City of Albuquerque

RE: ENGINEER CERTIFICATION FOR 3617 YUCCA NW (G11-D52) CERTIFICATION
STATEMENT DATE 5/11/93.

RE: REVISED DRAINAGE PLAN FOR 3617 YUCCA NW (G11-D52) REVISION DATED
3/9/93.

RE: DRAINAGE PLAN FOR 3617 YUCCA NW (G11-D52) ENGINEER'S PLAN DATED
2/26/93.

DESIGN BY:	
DRAWN BY:	DJH
GRADING AND DRAINAGE PLAN FOR 3617 YUCCA, N.W.	
RYALS	engineering & construction services
4929 Idlewild SE.	Albuquerque, NM 87108
(505) 265-8267	269-1146 mobile telephone
SHEET NO.	1 of 1

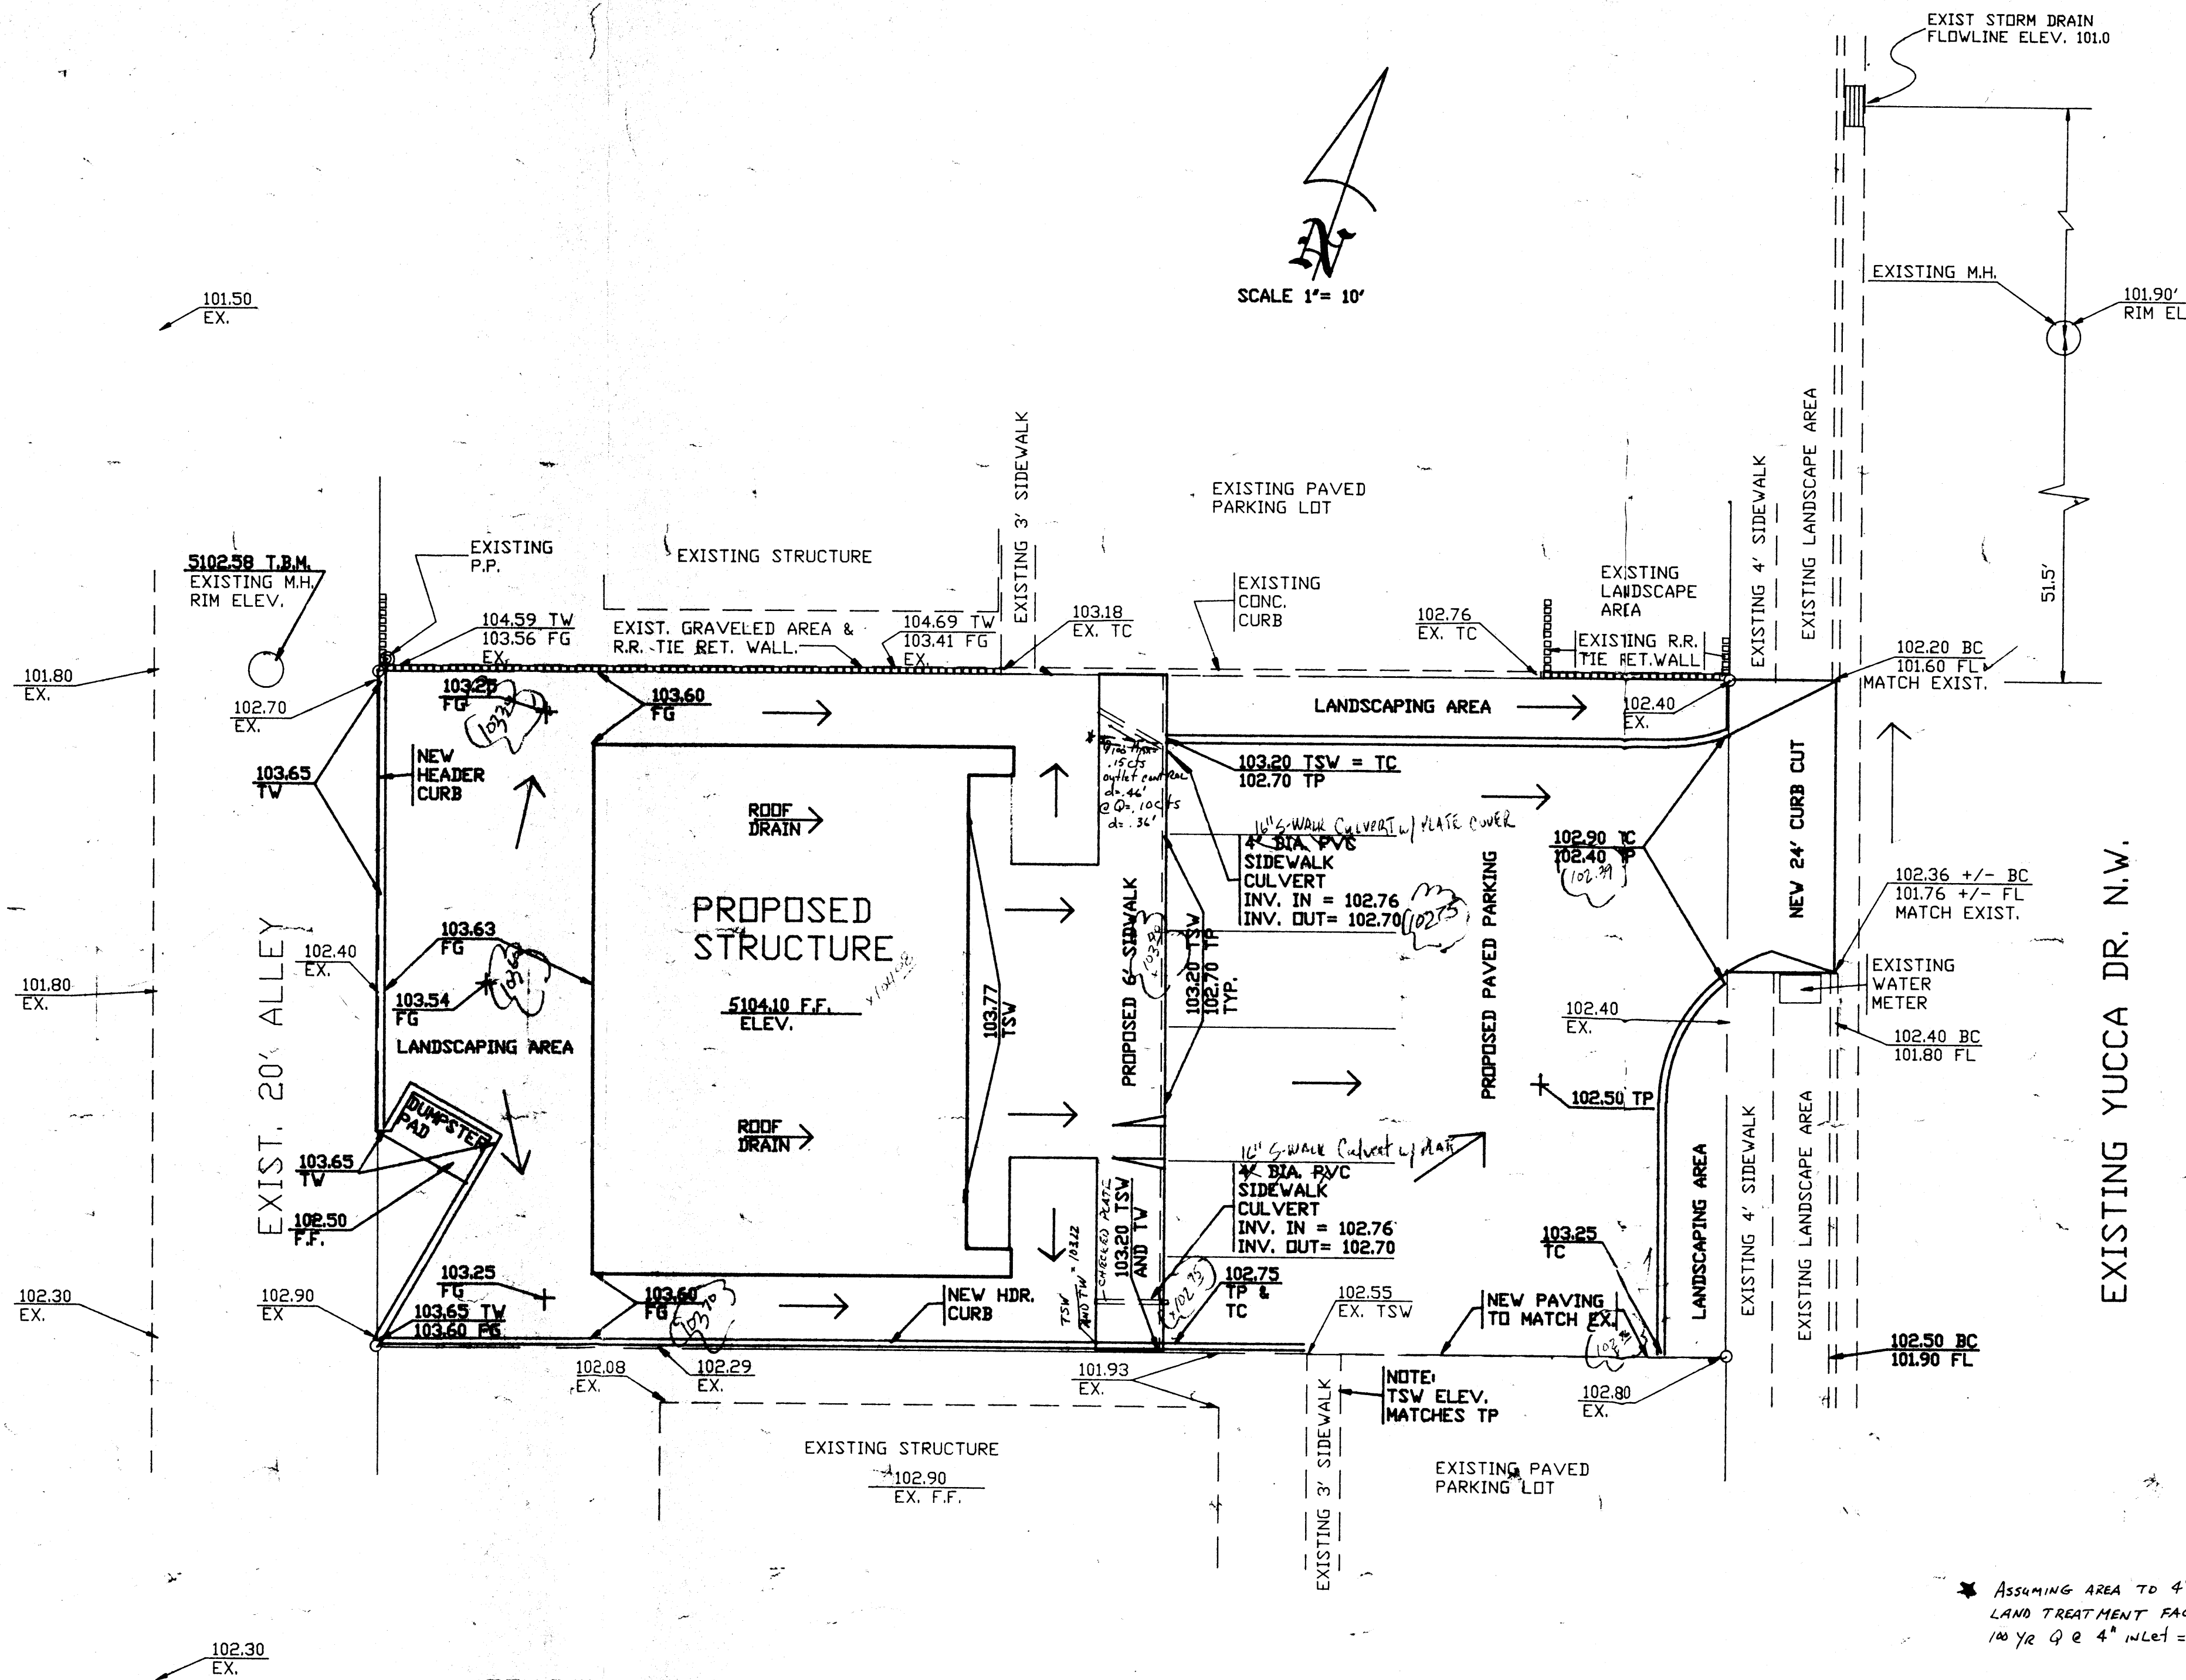
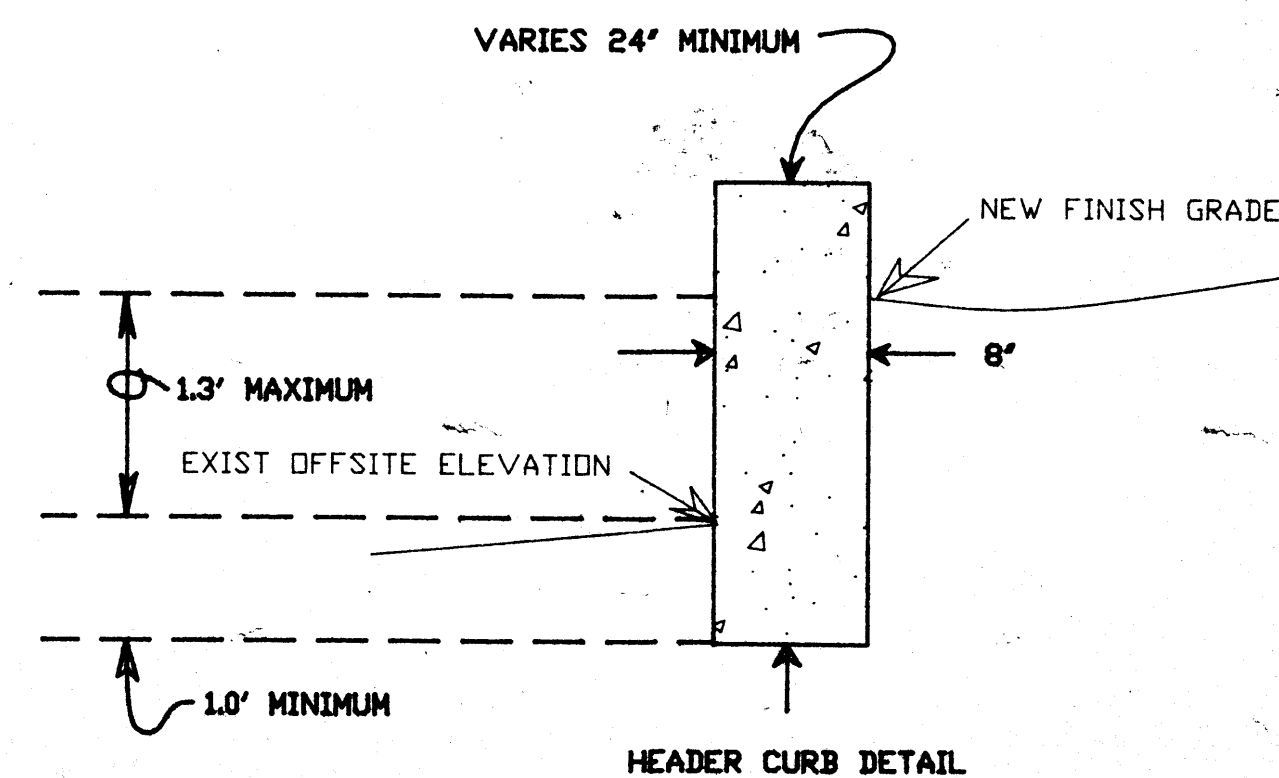
1. Finish floor elevation to full mean sea level.
2. what type of sediment control do you propose?
3. Basin that is being routed to each proposed p.v.c. pipe. Capacity of the 4" p.v.c. pipe.
